**City of Portland, Maine - Building or Use Permit**

<b>Permit No:</b> 05-0450	<b>Date Applied For:</b> 04/22/2005	<b>CBL:</b> 170 B017001
------------------------------	--	----------------------------

Convert unit #5 attic to bedroom w/ bath	Convert unit #5 attic to bedroom w/ bath
--	--

836 WASHINGTON AVE
570 Sq. Ft.

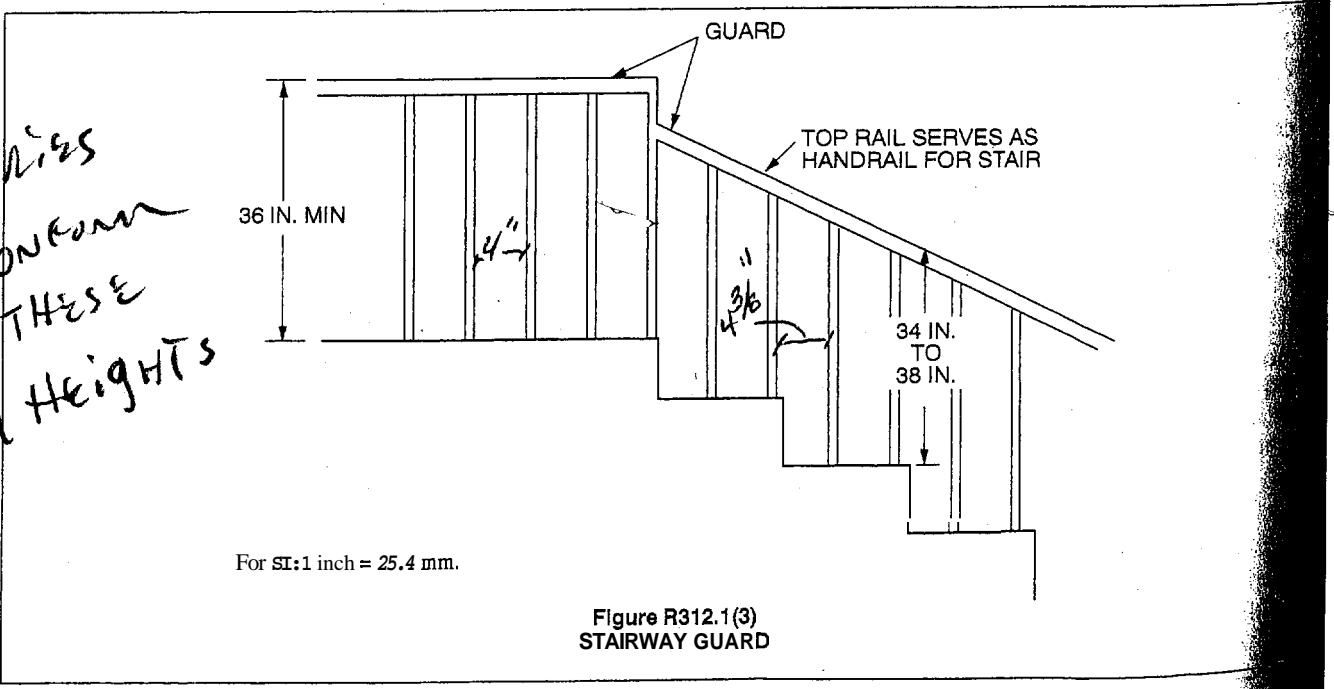
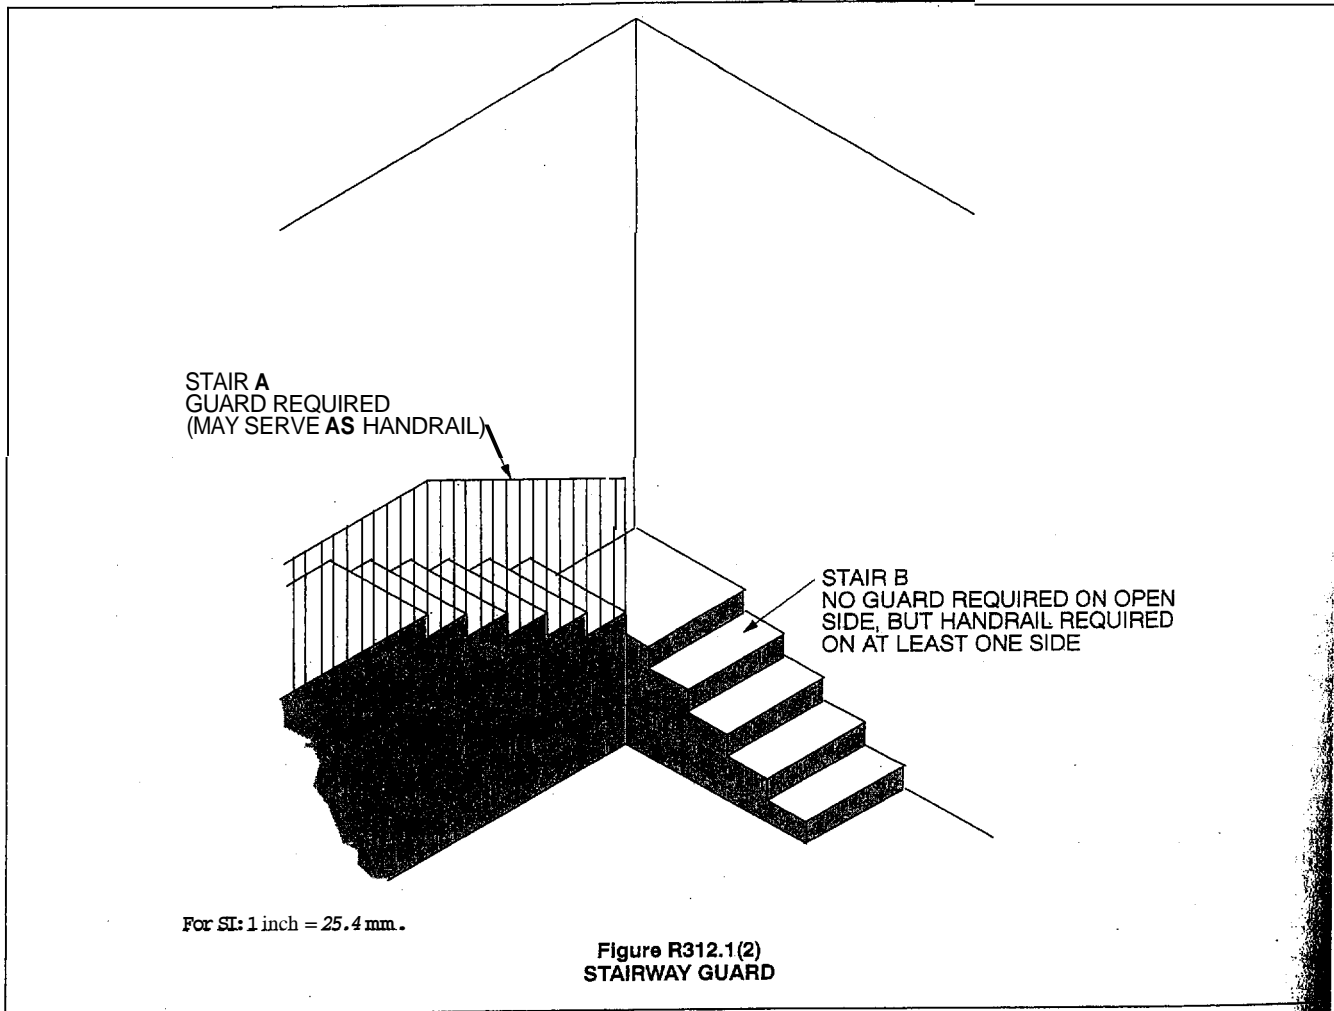
**Comments:**  
5/4/2005-mjn: Left message w/ plicant re: Headroom, Egress Windows ..other general Questions

EXISTING DETAIL OF STAIRS FROM 2ND FLOOR TO ATTIC

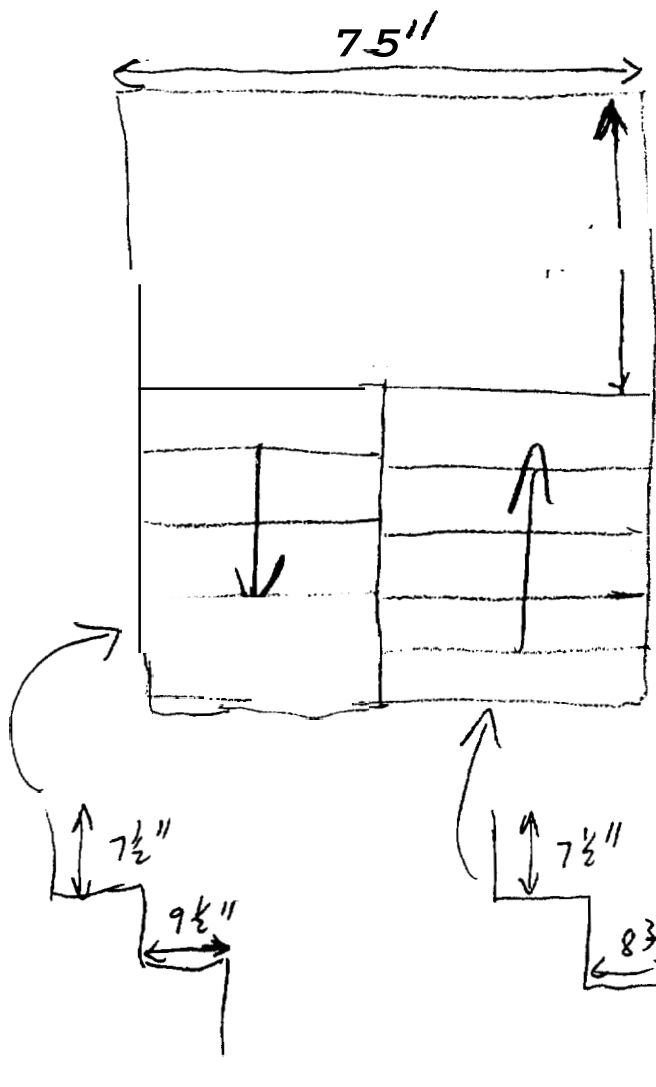
<b>Dept:</b> Building	<b>Status:</b> Approved with Conditions	<b>Reviewer:</b> Mike Nugent	<b>Approval Date:</b> 05/06/2005
<b>Note:</b>			<b>Ok to Issue:</b> <input checked="" type="checkbox"/>
<p>1) Guard details insufficient, all elements must comply with regard to height, balluster spacing, loading and graspability</p>			
<b>Dept:</b> Fire	<b>Status:</b> Approved with Conditions	<b>Reviewer:</b> Jay Kelley	<b>Approval Date:</b> 05/03/2005
<b>Note:</b>			<b>Ok to Issue:</b> <input checked="" type="checkbox"/>
<p>1) Permit is issued for Bedroom addition only not for third floor unit</p>
